ENG-CDR23021-R1-FDR-S2.pdf Markup Summary

Author: Jeff Rice - EPC Engineering Review

SHEET DRN 1  
 PROPOSED CONDITIONS - DRAINAGE MAP

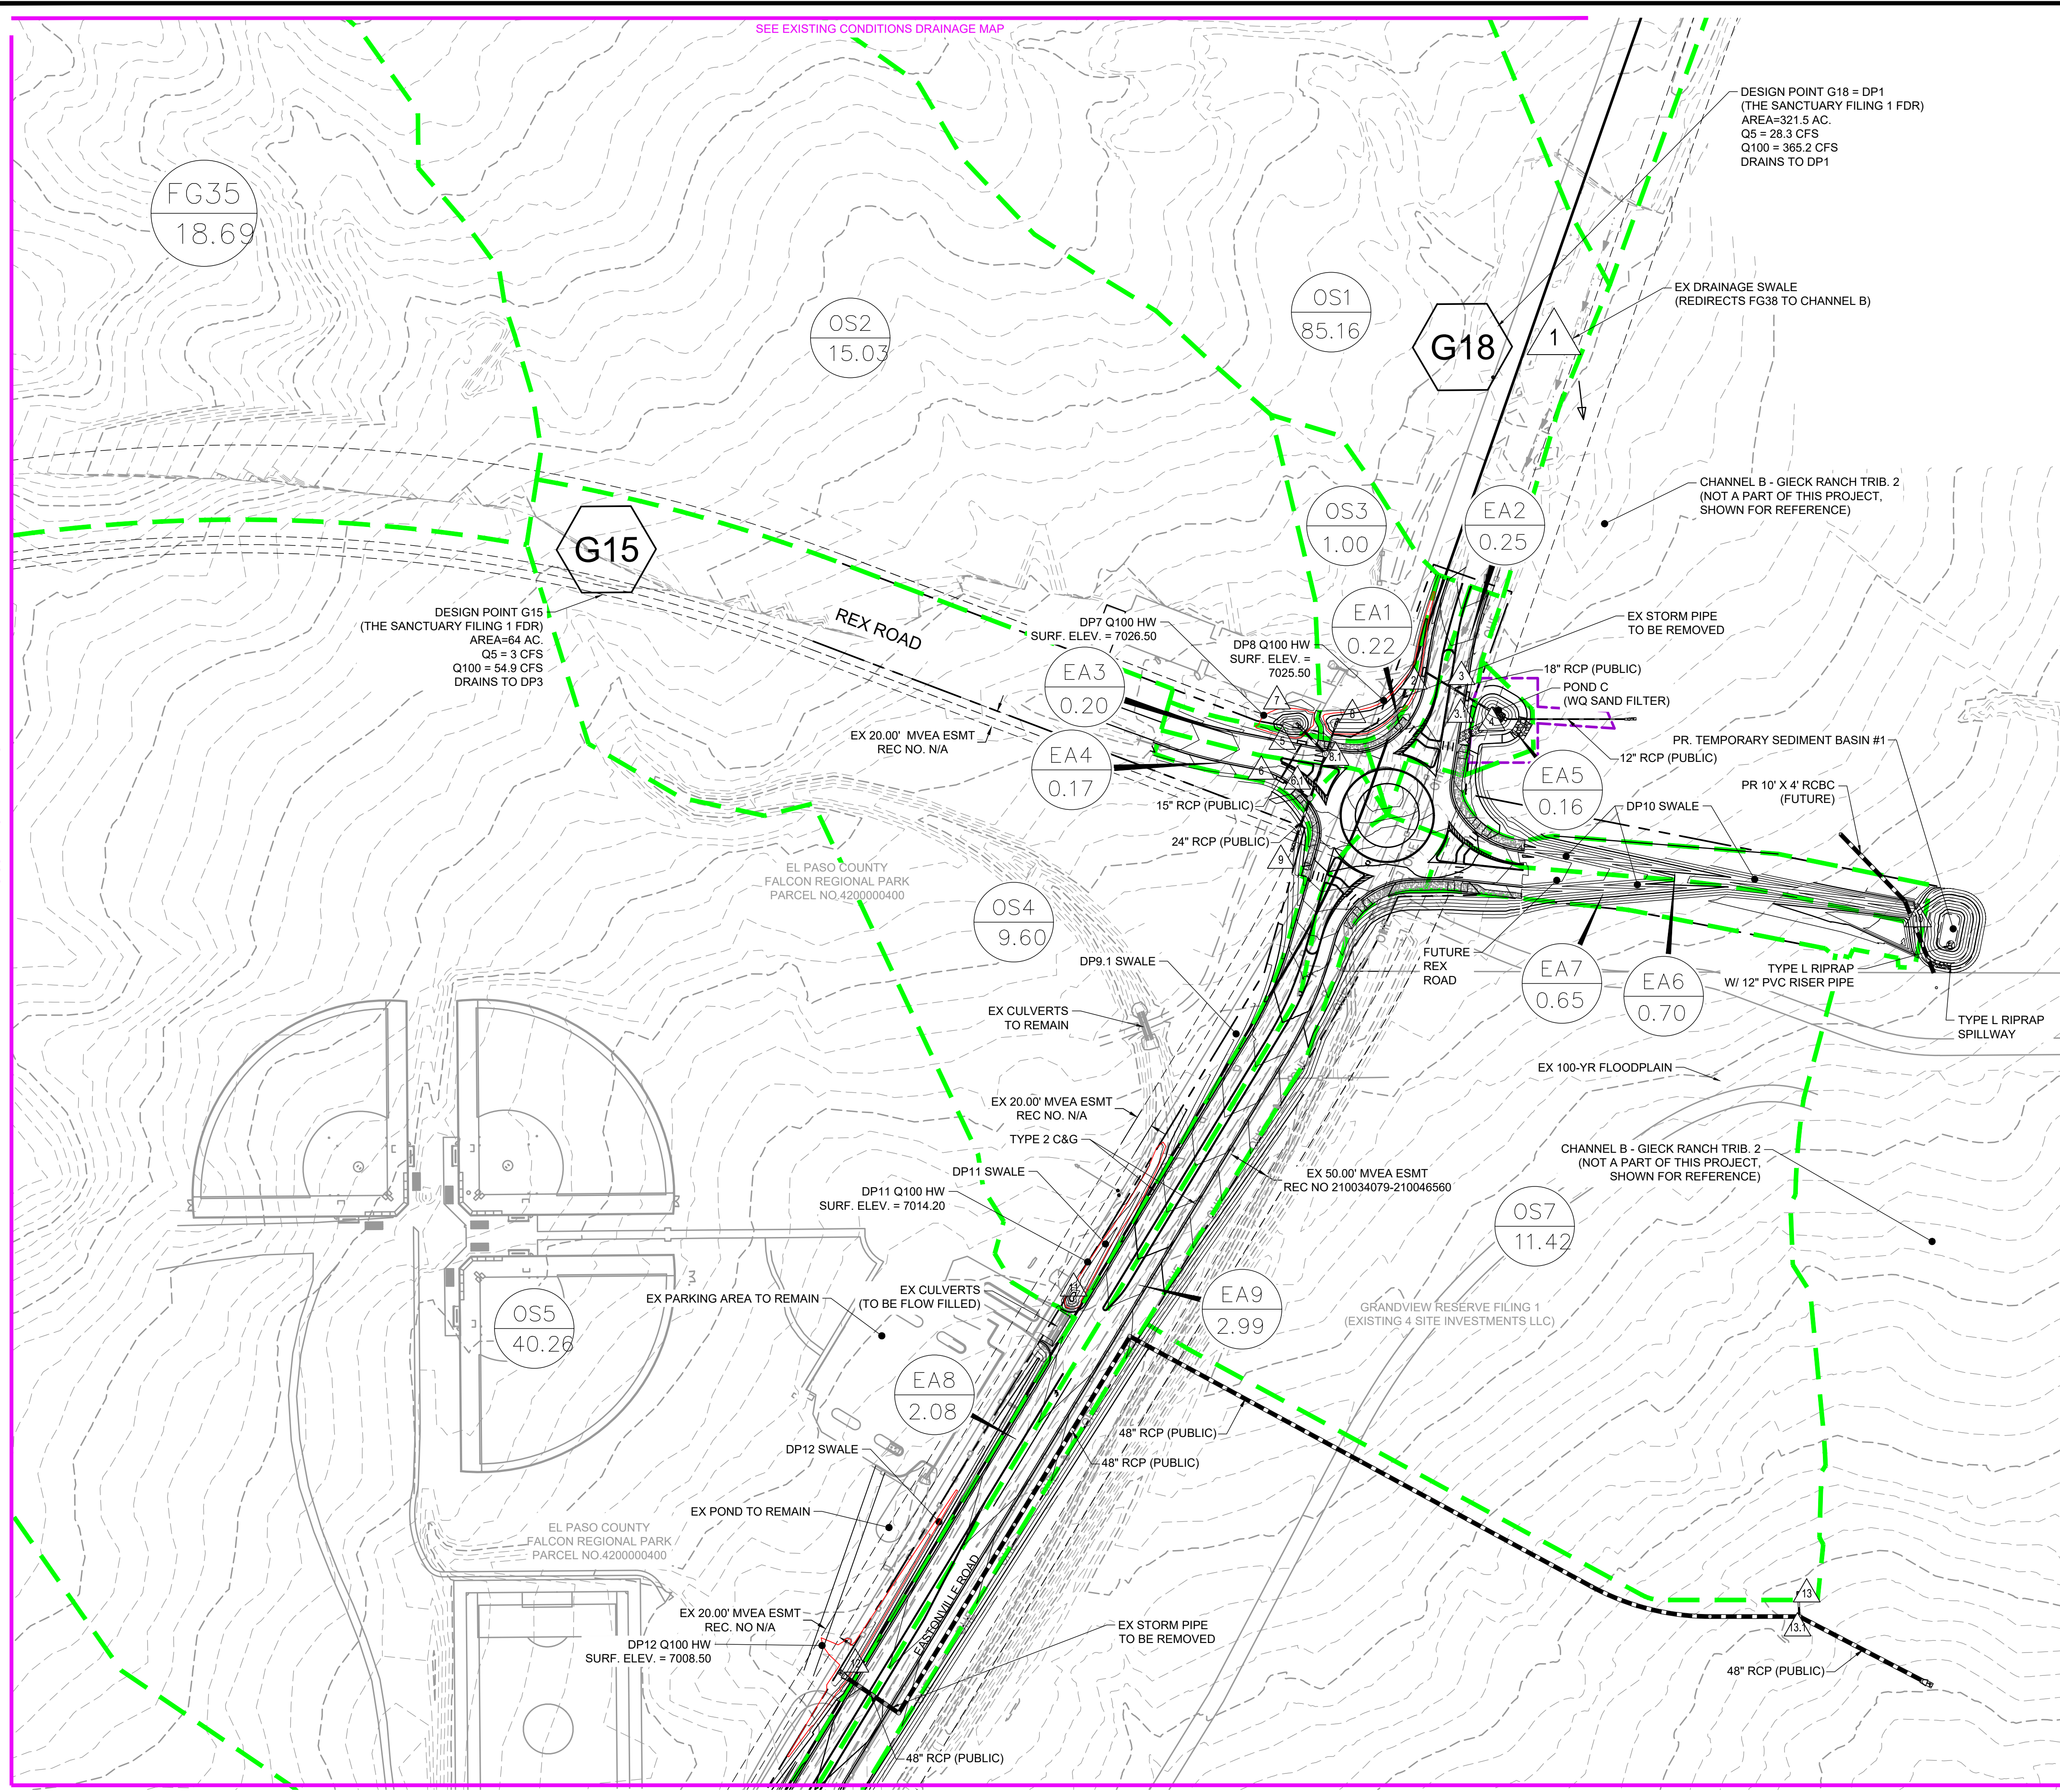
See my comments on the drainage maps for Segment 1. Those comments also apply to these Segment 2 drainage maps.

Add additional contour labels
